Lime Down

Solar Park

Statement of Common Ground with Environment Agency (Clean)

Planning Inspectorate Reference: EN010168

Title:
Figure 11.3 Rev 4: Lime Down C1 Fluvial
and Surface Water Flood Risk Map

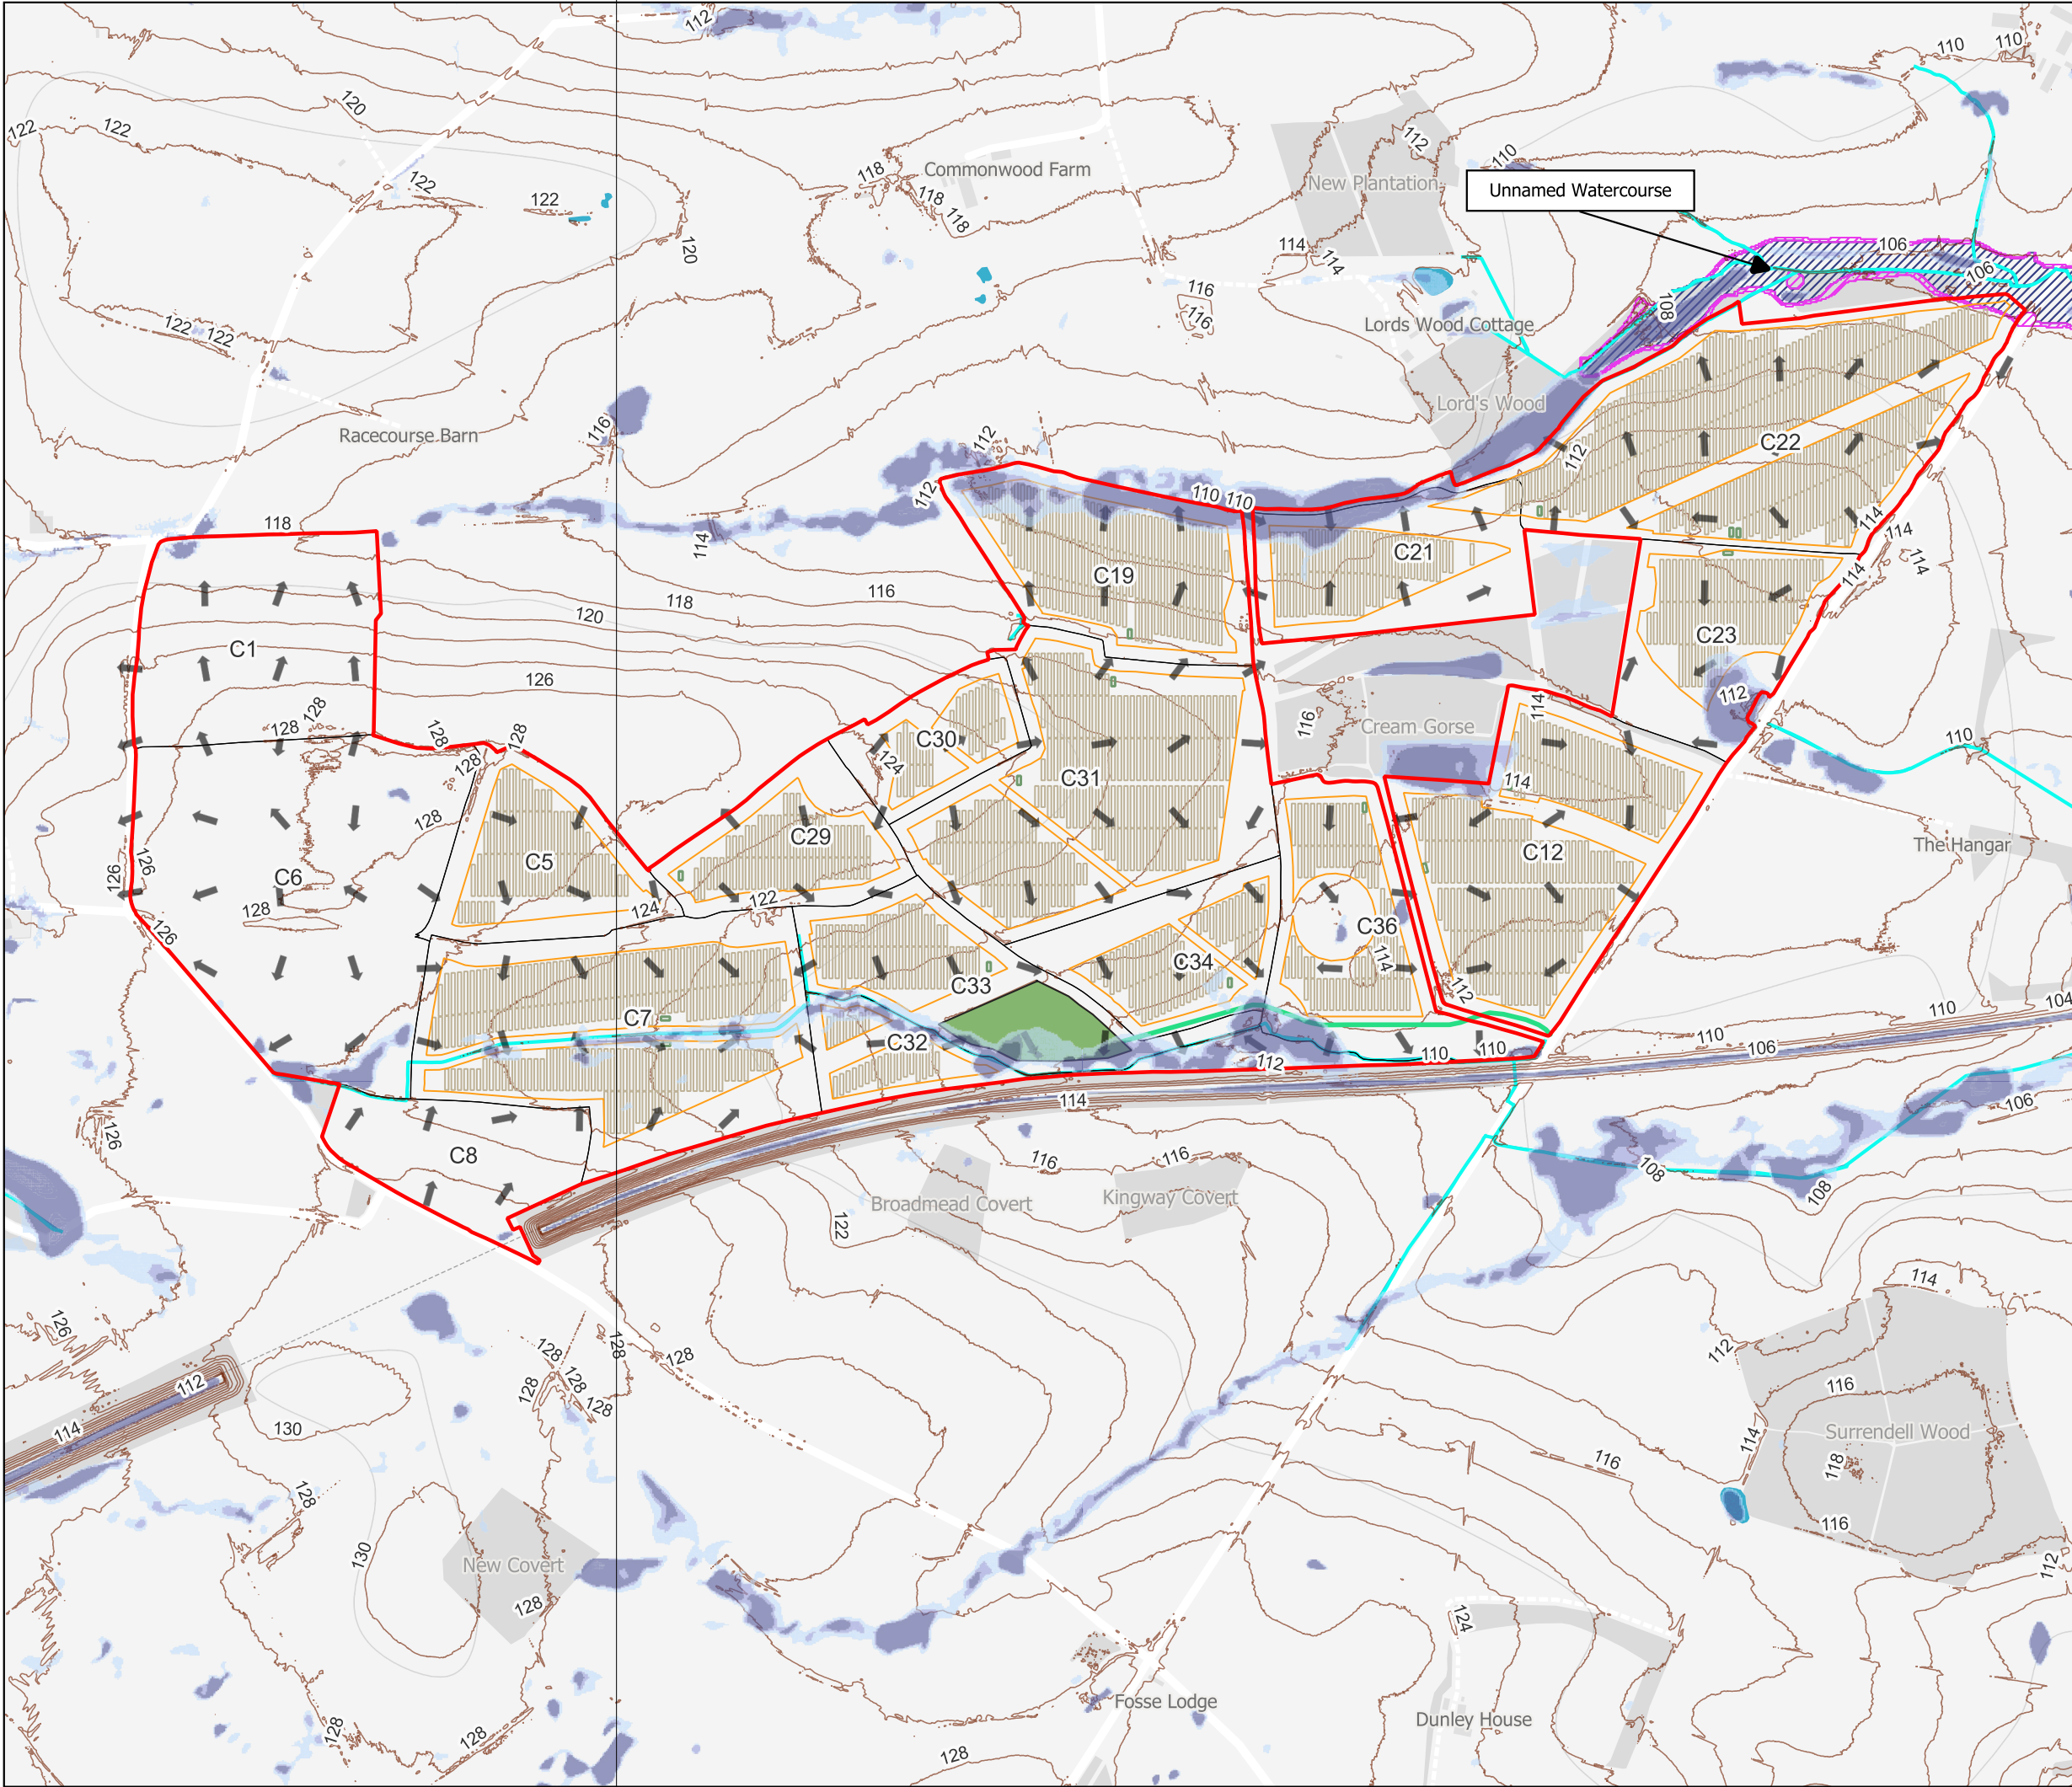
3.3.10	Floodplain Interaction and Displacement	The Environment Agency has requested clear reporting and evidence of floodplain displacement assessment to demonstrate flood risk neutrality.	The Applicant notes that this matter has been addressed in the revised floodplain displacement assessments submitted at Deadline 1. and further reported in the Applicant's response to	Under Discussion

Reference	Sub-topic	EA Position	Applicants Position	Status
		If it is not possible to place the substation within Lime Down C1 outside of the mapped flood flow routes, further assessment will be undertaken at detailed design to determine if the placement of the substation within Lime Down C1 would increase flood risk elsewhere. If there is an increase to flood risk elsewhere, floodplain compensation will be provided, in consultation with the Environment Agency, to ensure that there is no increase in flood risk. Engagement with the EA will occur throughout the detailed design stage on the need, method of calculating volumes, modelling and design of any floodplain compensation that may be required. We would need to secure this through a requirement within the Development Consent Order. We would request the following wording to secure this: Flood Mitigation Requirement <i>No development shall take place within Lime Down C1 until the location of the</i>	EA-049 in Applicant's Response to Comments Received at Deadline 2 [REP3-129]. The separate point raised by the Environment Agency in relation to the potential placement of the Lime Down C1 substation within mapped flood flow routes is addressed below. Interaction with the floodplain has been avoided where practicable through layout design. Where limited interaction remains, the Applicant has assessed displacement from the proposed solar panel supports using a deliberately conservative methodology. The assessment assumes displacement is redistributed only across the modelled flood extent within the relevant Lime Down site boundary, rather than across the wider hydraulically connected floodplain. This is precautionary, as in practice any displaced floodwater would be distributed over a substantially larger floodplain area. For Lime Down D, the assessment identifies a displaced volume of 11.59m³, redistributed across an on-

Reference	Sub-topic	EA Position	Applicants Position	Status
		<i>substation has been confirmed, an assessment of flood risk has been undertaken and a mitigation plan have been submitted to, and approved in writing by, the Local Planning Authority, in consultation with the Environment Agency, and these works shall be carried out as approved.</i> <i>Note:</i> <i>Should the assessment show increased flood risk, the mitigation plan should include a Floodplain Compensation Scheme. Any proposed compensation scheme must demonstrate:</i> <i>a) no net loss of floodplain storage within the design flood event;</i> <i>b) compensation provided on a level-for-level and volume-for-volume basis where appropriate;</i> <i>c) no increase in flood risk elsewhere;</i>	site modelled flood extent of 222,530m². This results in a theoretical increase in flood level of approximately 0.000052m. For Lime Down E2, the assessment identifies a displaced volume of 2.09m³, redistributed across an on-site flood extent of 50,735m². This results in a theoretical increase in flood level of approximately 0.000041m. In both cases, the calculated increase is de minimis, several orders of magnitude below the precision at which flood levels can be meaningfully defined, and would not result in any measurable change to flood levels, flood extents, flow routes or flood risk to third parties. The revised assessments also include figures showing the flood extent and displacement calculation areas for Lime Down D and Lime Down E2. The Applicant therefore considers that the assessment demonstrates flood risk neutrality and that compensatory flood storage is not necessary or proportionate. The Environment Agency has confirmed that the

Reference	Sub-topic	EA Position	Applicants Position	Status
		<i>d) implementation of compensatory storage prior to the associated floodplain loss; and</i> <i>e) appropriate maintenance of the compensation scheme is in place during the operation phase.</i>	Applicant has provided sufficient evidence to demonstrate that loss of floodplain storage would be negligible in the context of Gauze Brook and Gabriel's Well / Rodbourne Brook. In relation to Lime Down C1, the Applicant will continue to engage with the Environment Agency through detailed design on the siting of the substation, the need for any further flood risk assessment, and the method and design of any floodplain compensation or other mitigation that may be required. Any residual matter relating to the delineation or application of Flood Zone 3b is addressed separately under row 3.3.17. For Lime Down C1, the Applicant confirms that the 132 kV substation location remains subject to detailed design. The detailed design will first seek to locate the substation outside the mapped flood flow routes identified within Lime Down C1. If this is not practicable, a site-specific assessment will be undertaken at detailed design

Reference	Sub-topic	EA Position	Applicants Position	Status
			to confirm whether the substation would alter existing flood flow routes, displace flood storage or increase flood risk elsewhere. Where the assessment identifies a requirement for mitigation, this would be developed in consultation with the Environment Agency and may include floodplain compensation, localised level adjustments, conveyance measures or other design measures as necessary to ensure no increase in flood risk elsewhere. This is set out in FRA Appendix 11-6: Lime Down D / BESS [REP3-056], paragraphs 2.3.23 to 2.3.29 and Figure 8, FRA Appendix 11-8: Lime Down E2 [REP3-061], paragraphs 2.3.16 to 2.3.21 and Figure 8, and the wider ES Volume 3, Appendices 11-1 to 11-9: Flood Risk Assessment and Drainage Strategy [REP3-039, REP3-49 to REP3-064].
